Application No.: 02DRB-00609 (P&F)

Project Name: EL RANCHO GRANDE 1 - UNITS 9A & 9B

Project #1001897
Application # 02DRB-00609, 02DRB-00610
El Rancho Grande 1, Tracts 9A & 9B

ALDRICH LAND SURVEYING INC agent(s) for CURB INC request(s) the above action(s) for all or a portion of Tract(s) B (to be known as **EL RANCHO GRANDE - 1 (Tracts 9A & 9B)**, D & S Addition, zoned R-2 - SU2/SF, located on BLAKE RD SW, between UNSER BLVD SW and SNOW VISTA BLVD (98TH ST) SW containing approximately 53 acre(s). [REF: Z-73-179, AX-73-33] (N-9)

BLUK LAND PLAT FOR
EL RANCHO GRANDE I
TRACTS 9-A AND 9-B
 WITHIN THE
 TOWN OF ATRISCO GRANT
 PROJECTED SECTION 4
 TOWNSHIP 9 NORTH, RANGE 2 EAST, NMPM
 CITY OF ALBUQUERQUE
 BERNALILLO COUNTY, NEW MEXICO
 APRIL, 2002

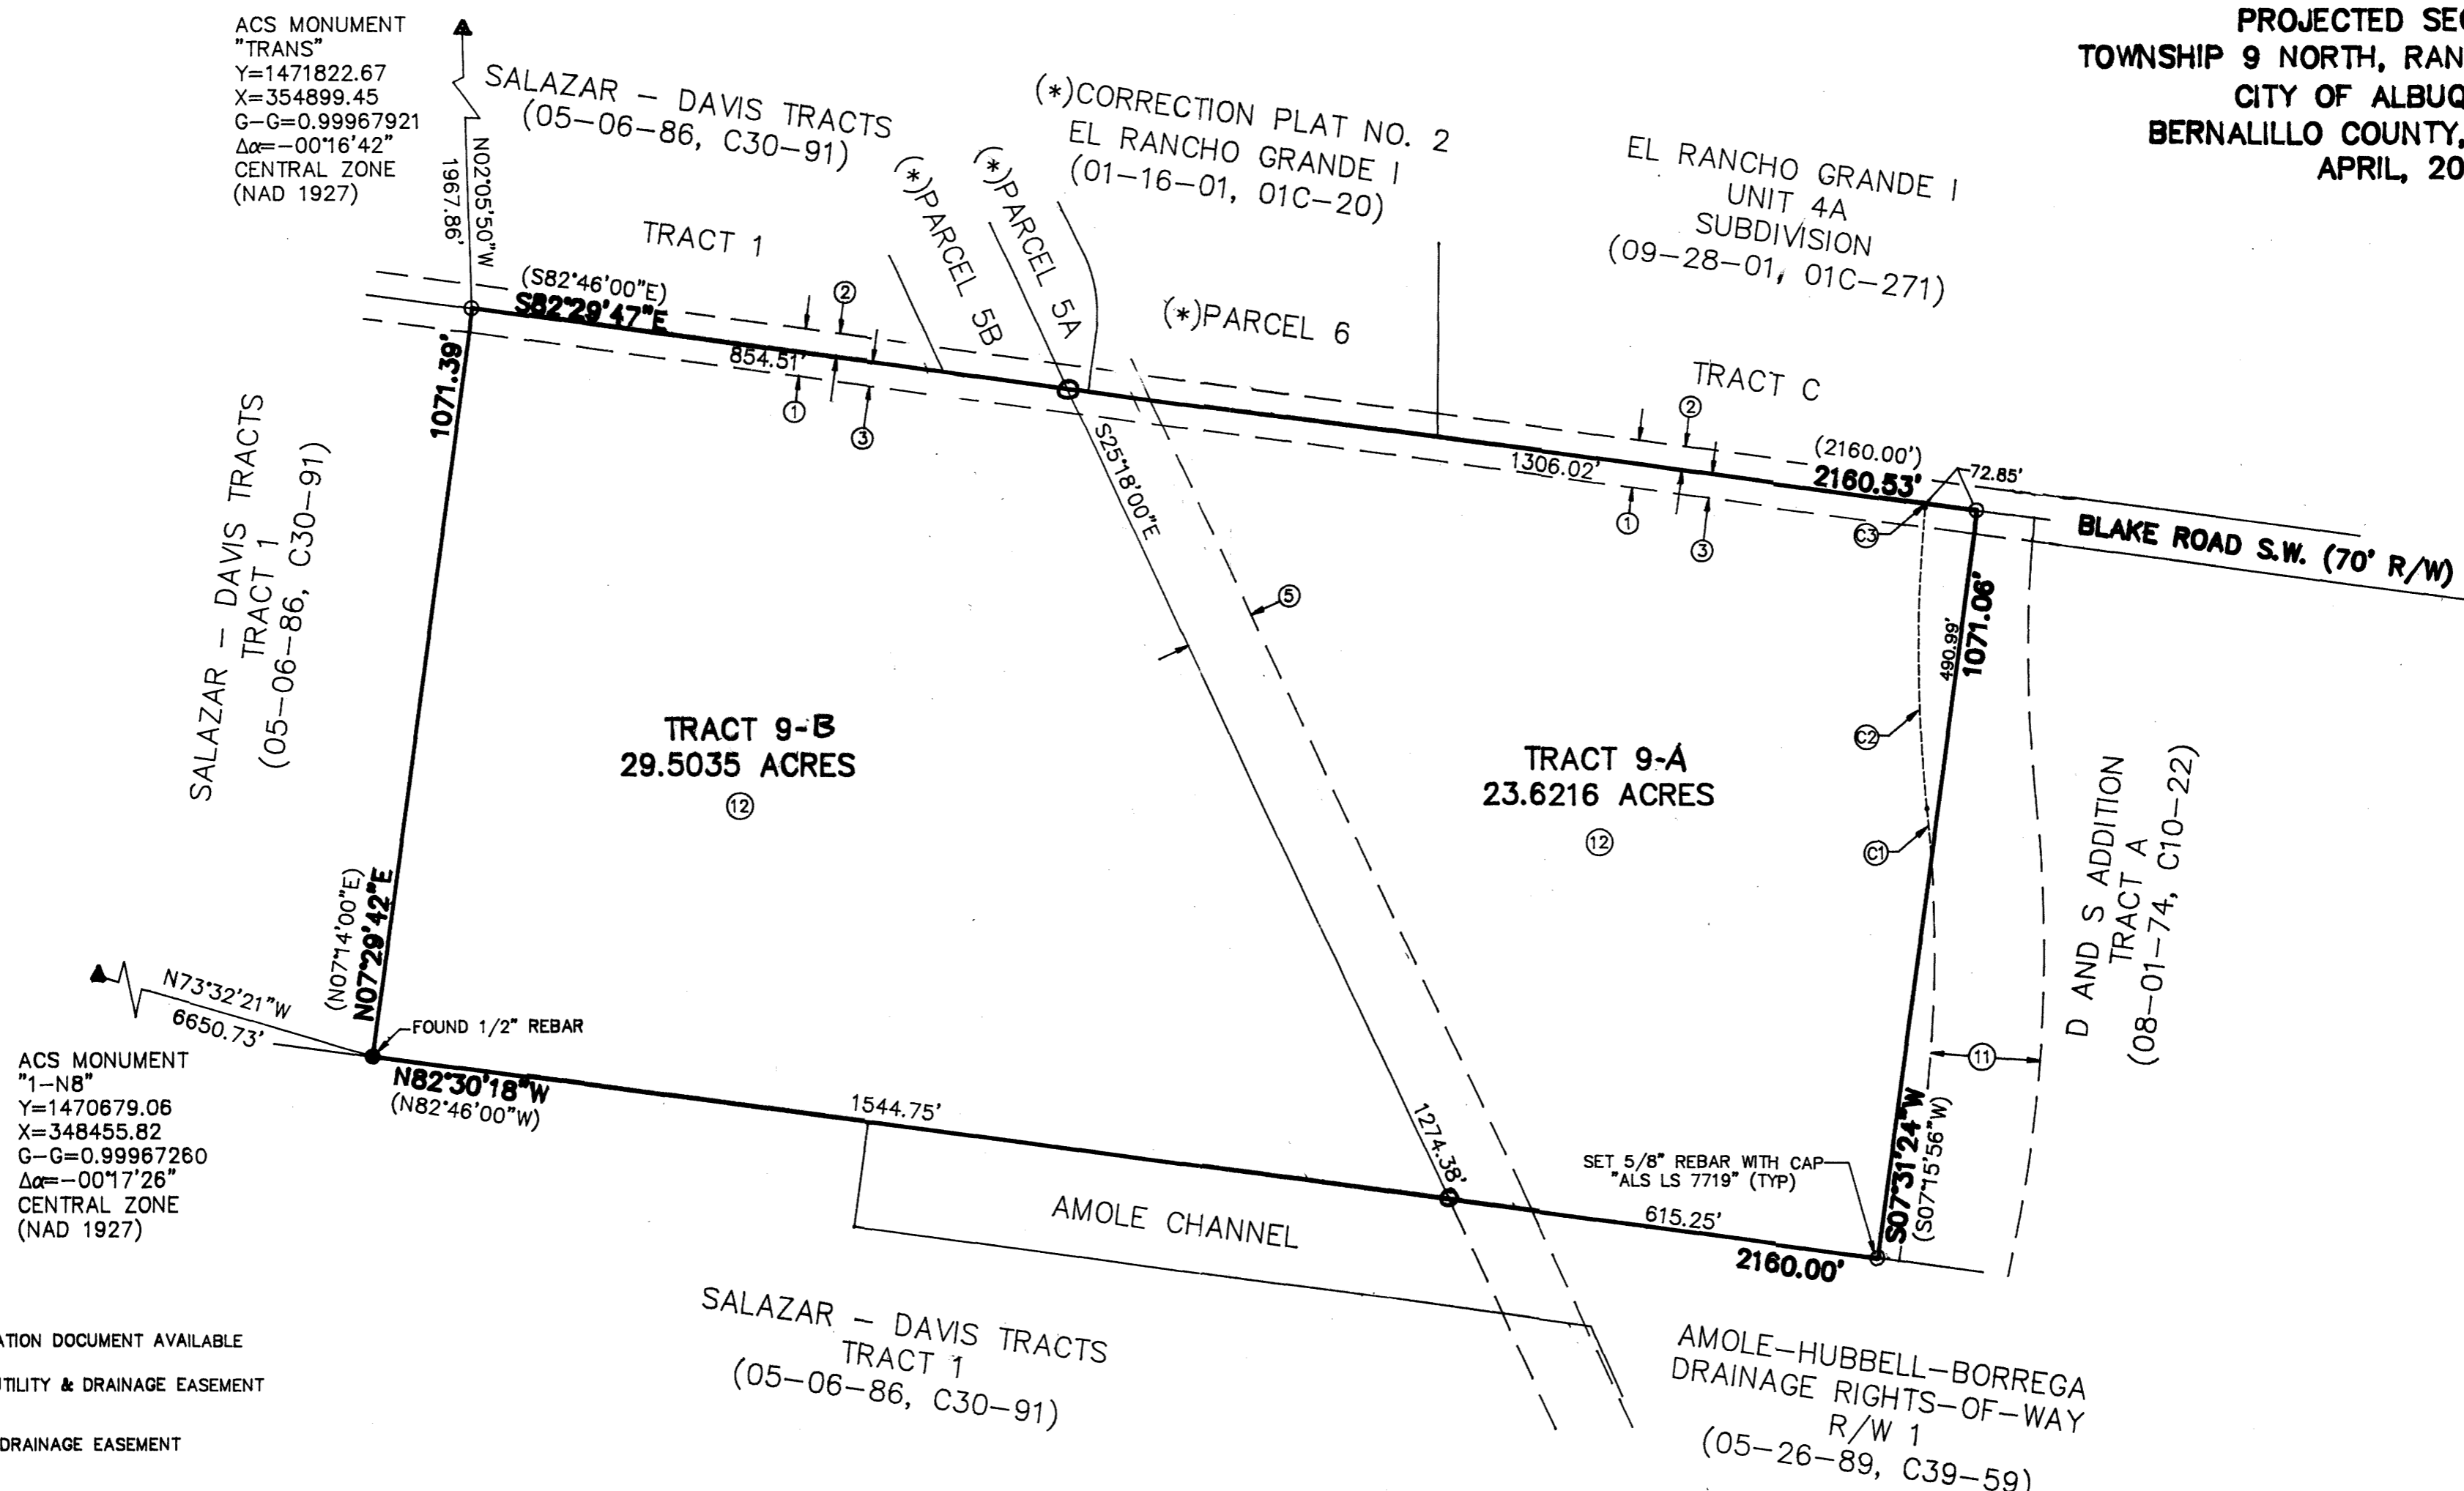
5. Add the zoning classification to the *Subdivision Data* section on the plat.
 6. Minor subdivision plats and those not completing vacation actions may be recorded by the applicant/agent. A copy of the recorded plat must be provided to Planning in order to close the case file.

AMAFCA 1. No objection to requested action. 2. AMAFCA could find no reference to an existing blanket drainage easement on Tract B, as stated in Note 12. 3. Show the existing FEMA floodplain and grant drainage easement to the floodplain limits. 4. Reference "AMAFCA" in call-out for AMAFCA facilities.

Identify Unser Boulevard. Show all adjacent access easements filed to date. No objection to the bulk land variance.

Tract 9-A must include easements for existing flood plain and for road and utility corridors.
